ENG-SKP22005-R2-TIS-redlines.pdf Markup Summary

Figure 2
SKETCH PLAN

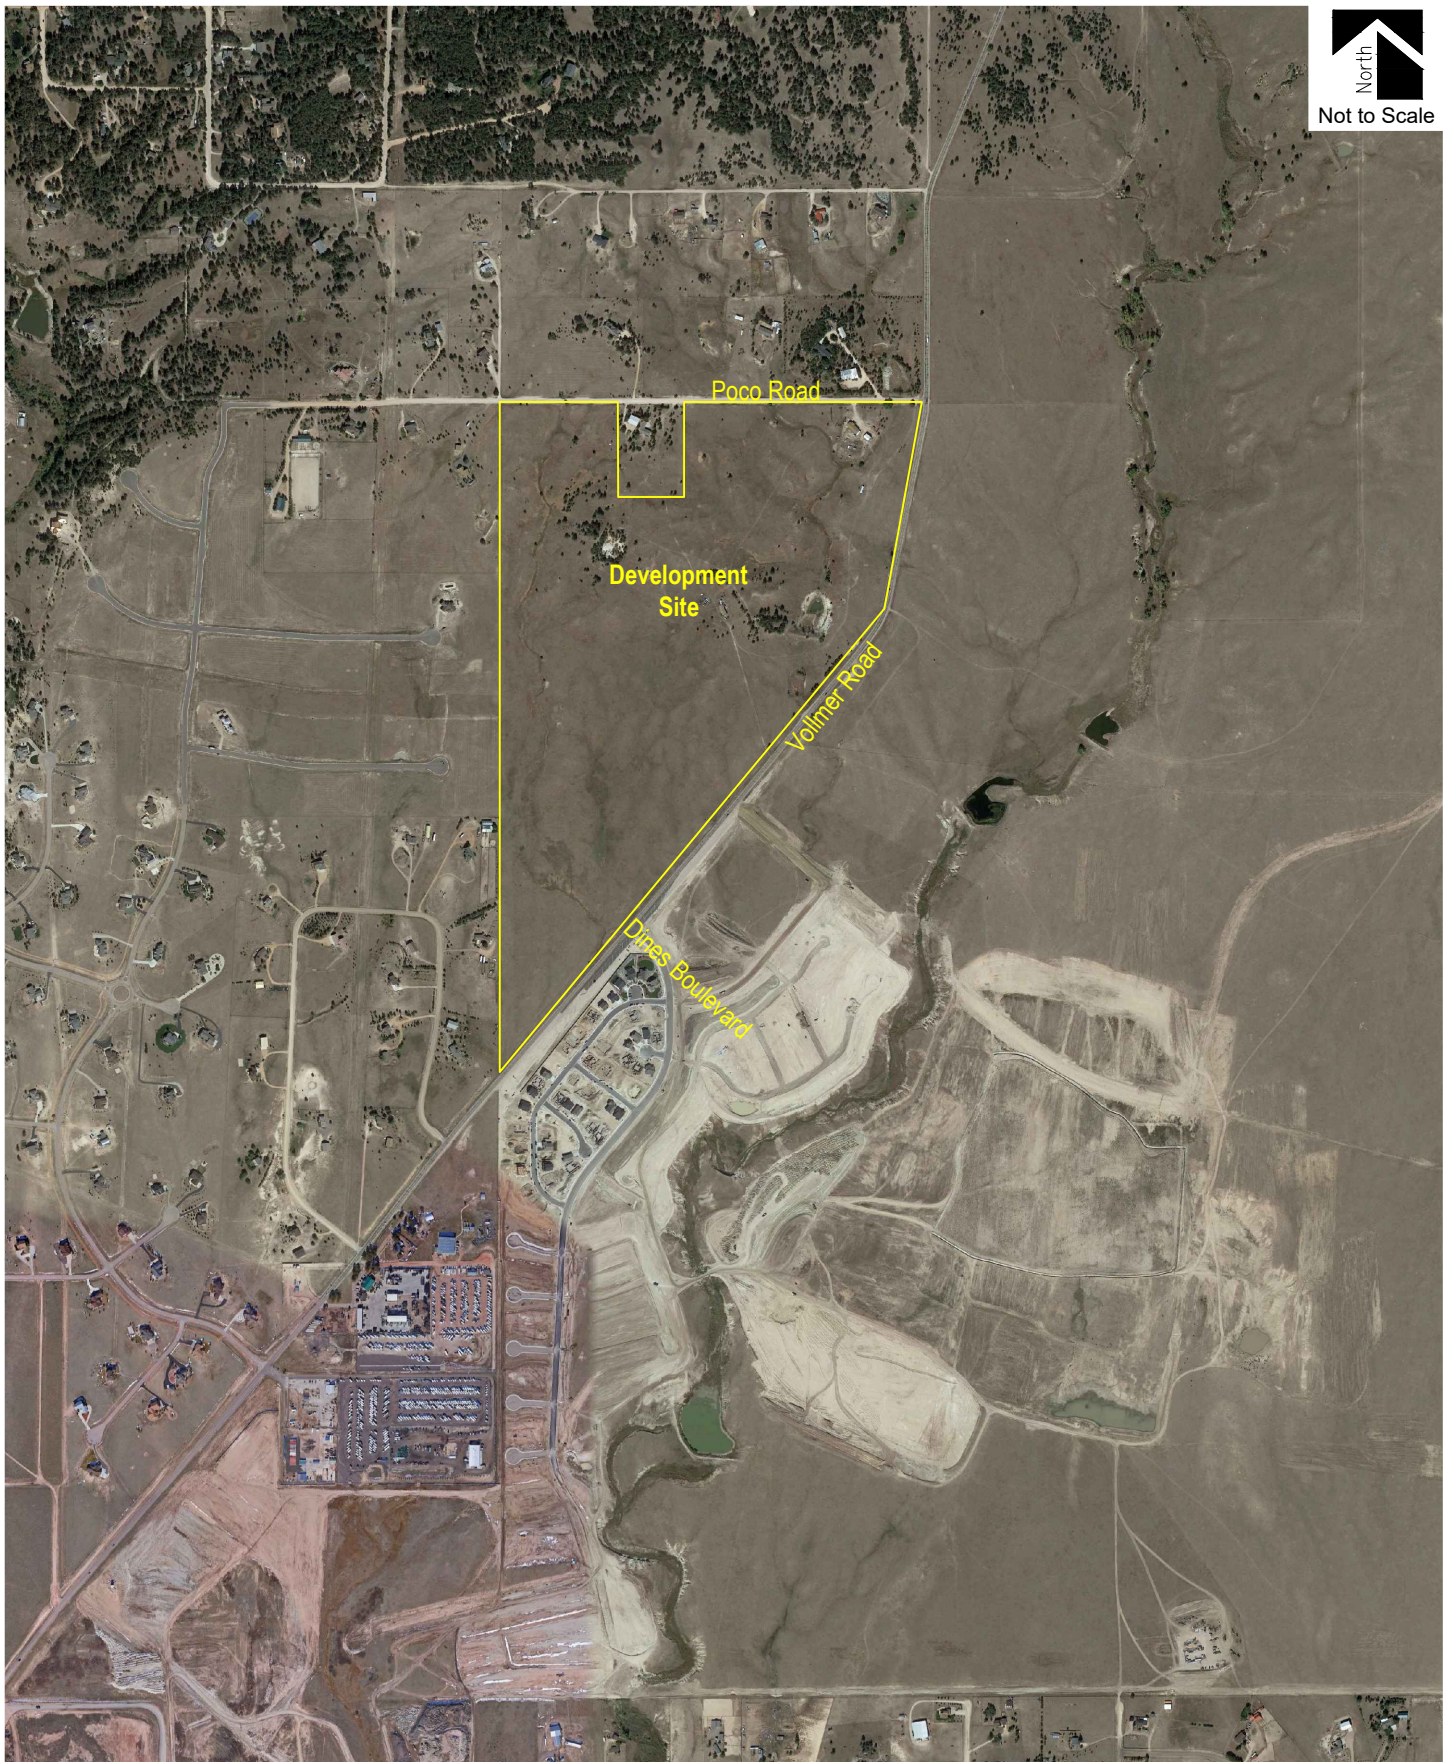
Clarify - full movement is unlikely here; possibly RI/RO or 3/4 only because of vertical alignment on east side.

We understand that a sketch plan is conceptual, but the location of this intersection will reduce the chances of any additional access being granted between here and Vollmer Road. The intersection should be approximately 400-500 feet from the west property line on the ridge, at least 1,000 feet to Vollmer Road.

Delete this arrow

Figure 8
TOTAL TRAFFIC - YEAR 2040
Volumes & Intersection Geometry
AM / PM Peak Hour
(ADT) : Average Daily Traffic

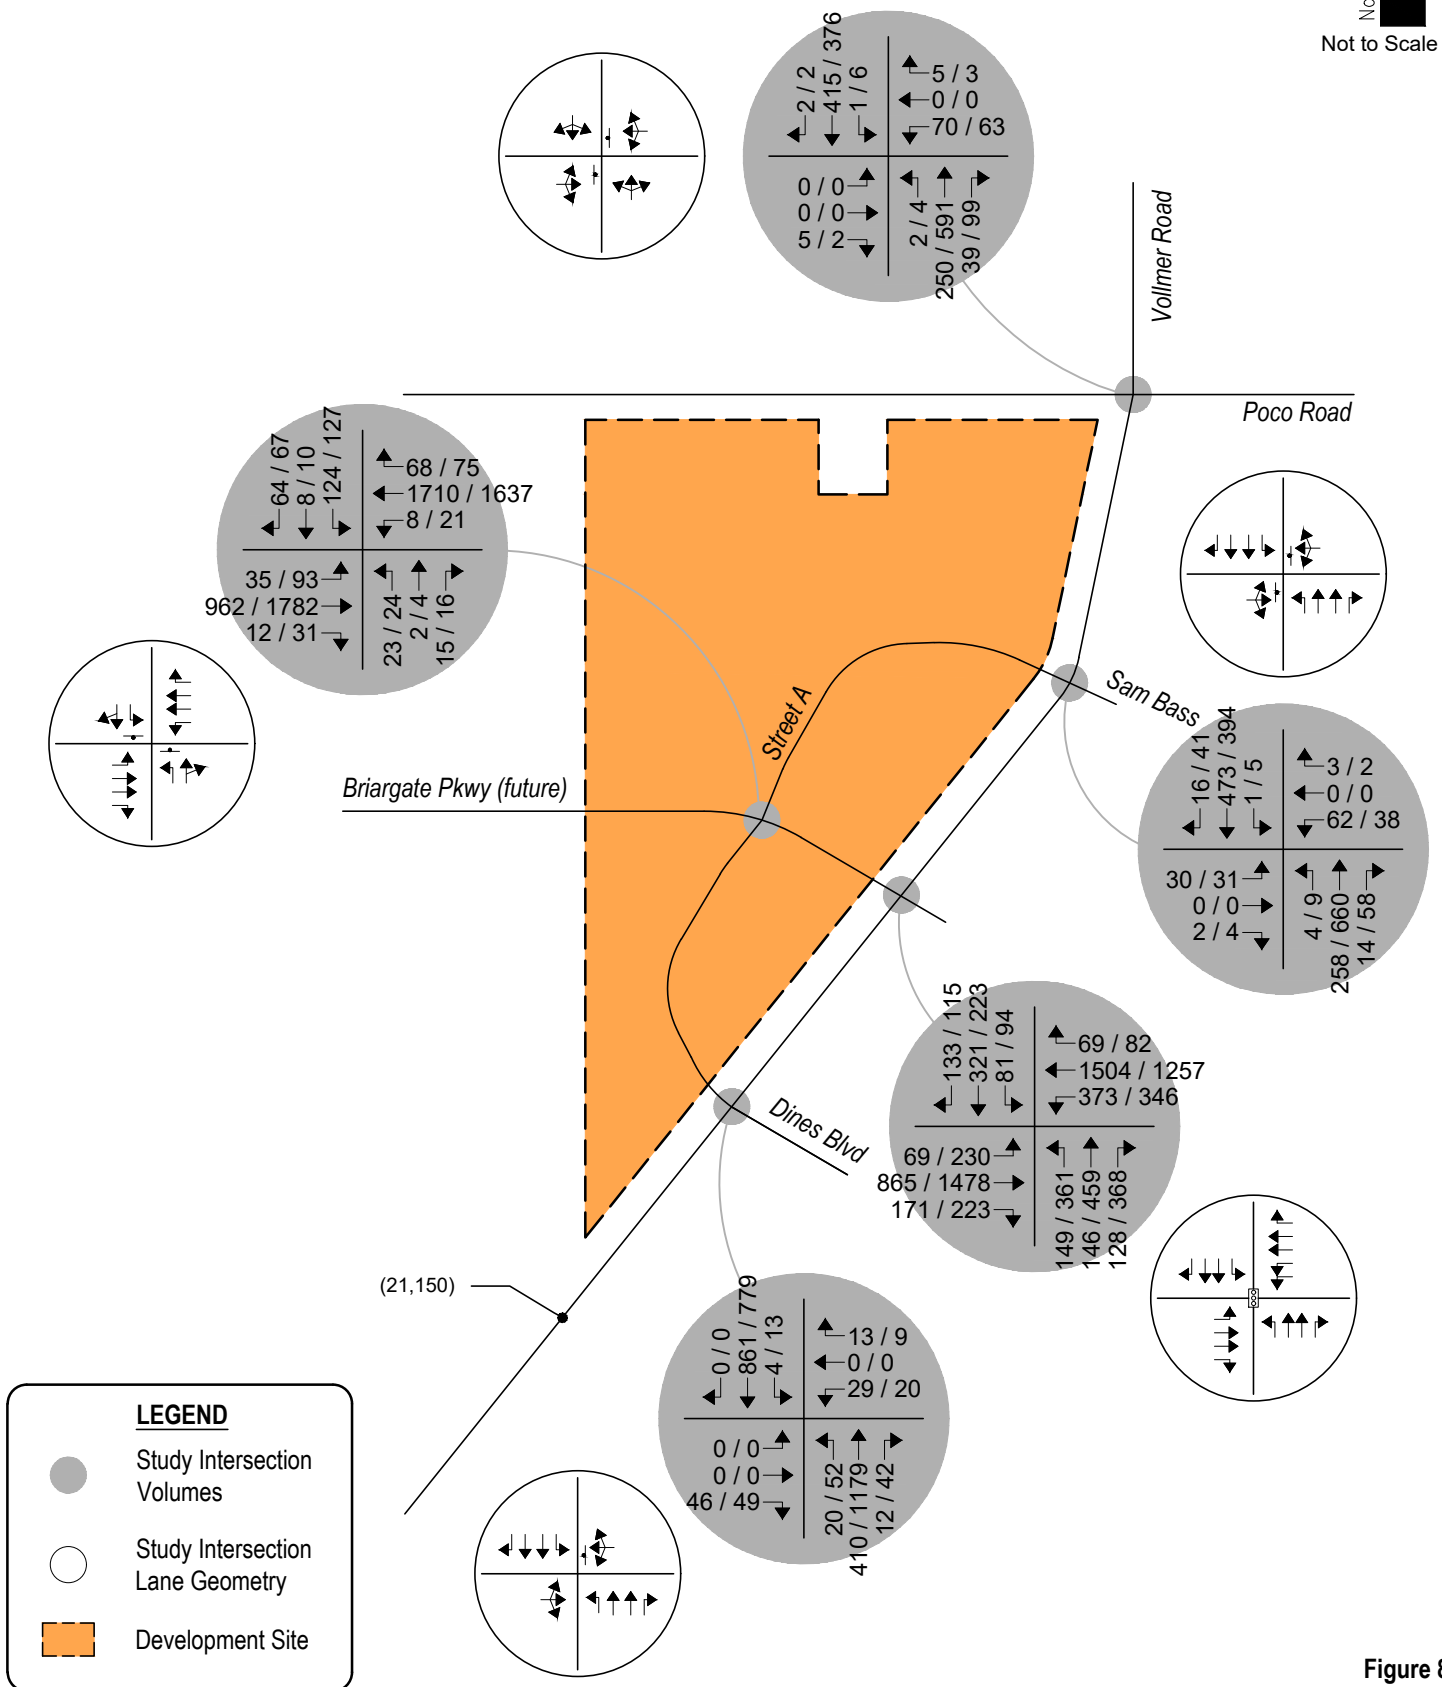
All of the 2040 PM Total poor (E&F) levels of service at Briargate/Vollmer except the EBL appear to be caused by the project - address why and what mitigation would help. Address potential need for 2nd northbound left turn lane.

Could need 2 LT lanes?

All of the poor (E&F) levels of service except the EBL appear to be caused by the project - address why and what mitigation would help.
